**Re: 6309 Camino Alto NW  
S.A.D. 228 Lot 15 Block 2  
Grading and Drainage Plan  
Engineer's Stamp dated: 12/22/2016 (D10D003C15)**

**Re: 6309 Camino Alto NW Residence (SAD 228)  
Engineers stamp date 12-22-16 (D10 /D\_\_\_)**

**From:** Rael, Rudy E.  
**Sent:** Friday, December 16, 2016 9:01 AM  
**To:** "Diane Hoelzer" (Diane@goodwinengineers.com)  
**Cc:** Carrillo, Abiel X.  
**Subject:** 6309 Camino Alto NW

**ROYBAL RESIDENCE**  
**6309 CAMINO ALTO N.W.**  
**GRADING & DRAINAGE PLAN**

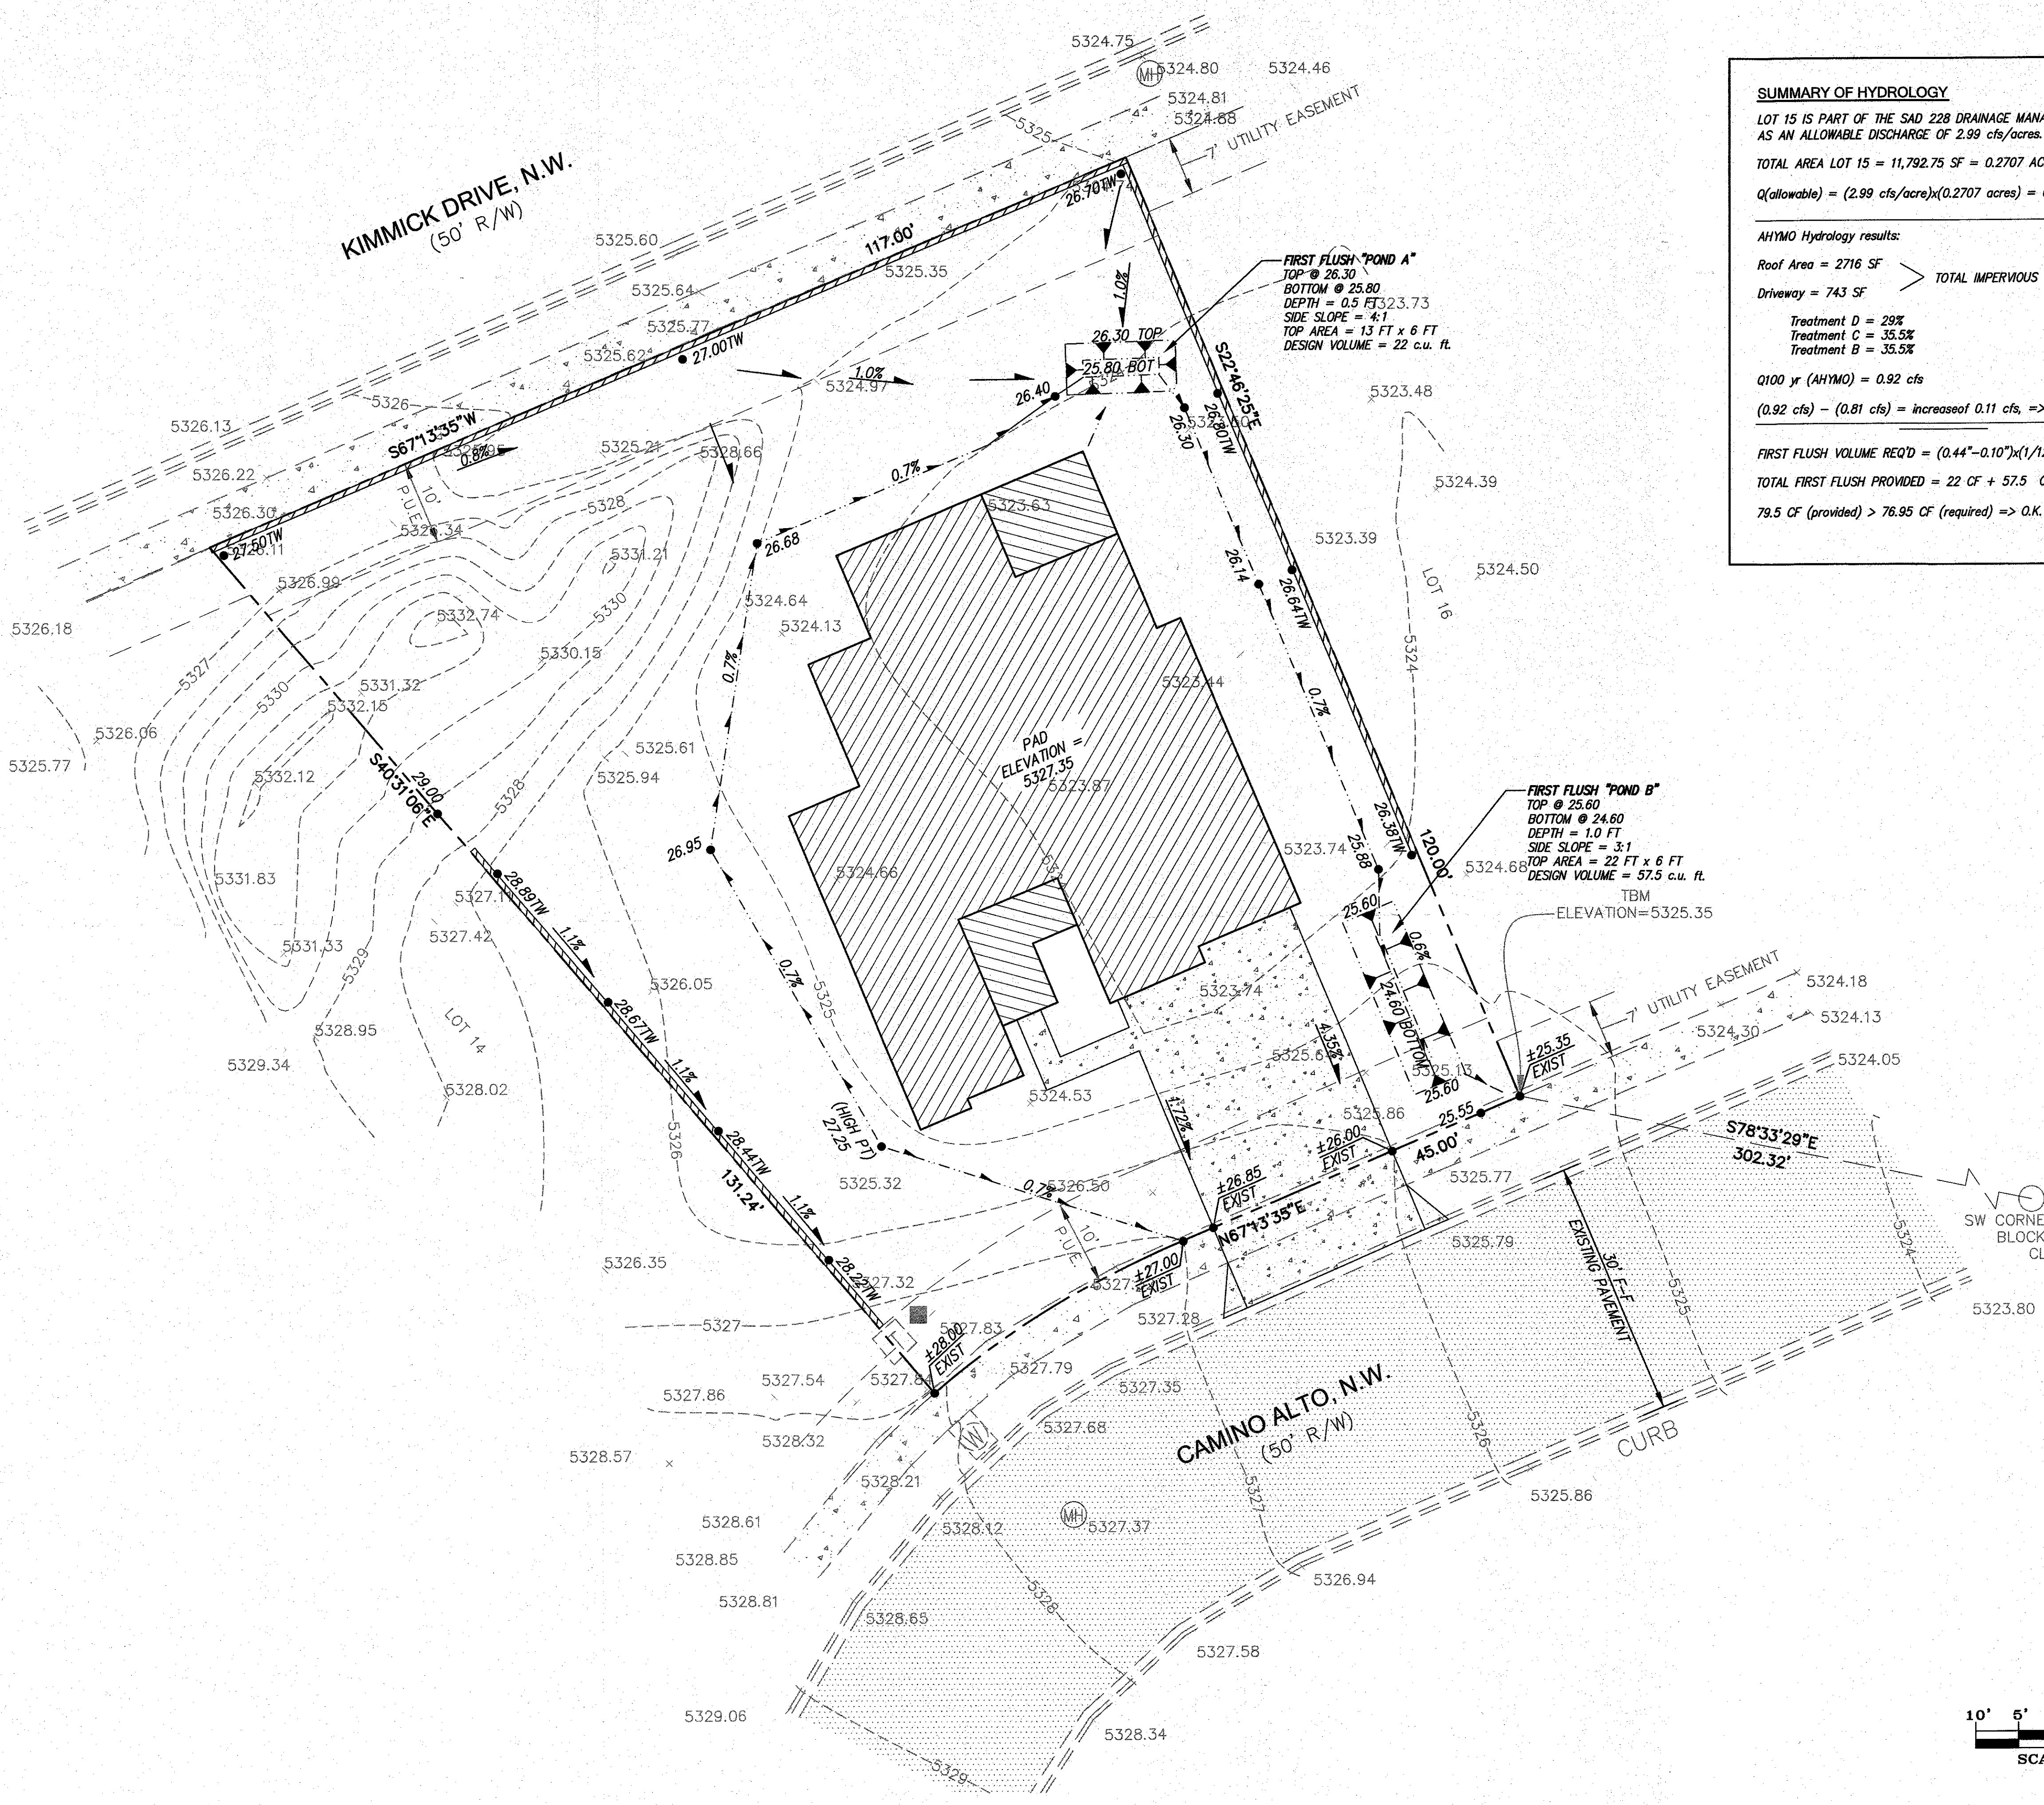
Based upon the information provided in your submittal received 12/12/16, the above referenced Grading and Drainage plan dated 12/9/16 cannot be approved for Grading Permit or Building Permit until the following comments are addressed:

- Provide flows exiting the rear yard, these flows are to enter the existing pond on the west side of Kimmick St.
- Provide the proper size openings in the rear walls for cross lot draining.
- Provide a note on the plans requiring the openings to be 3" above grade.
- Provide a note stating that retaining walls and garden walls require a separate permit. Also let the owner or contractor know that the retaining wall requires an engineer certified plan. If you are not the engineer for the walls provide a note stating that walls are being certified by others.
- Provide a note about the Special Flood Hazard Area (SFHA).
- Provide a note that a Pad Certification is required before pad is poured.

1. The flows from this site have been modified in response to our meeting. Part of the flow is directed to the first flush pond located at the NE corner of the lot with runoff overflow conveyed through two turned blocks at the boundary. A second first flush pond at the SE corner of the property with runoff overflow directed to Camino Alto road.
2. Opening size has been provided on the plan.
3. The spillway elevation from the pond is set at 0.2' higher than the adjacent property as shown on the plan.
4. The note has been added to the construction notes.
5. This has been provided on the plan.
6. This note has been provided in the construction notes on the plan.
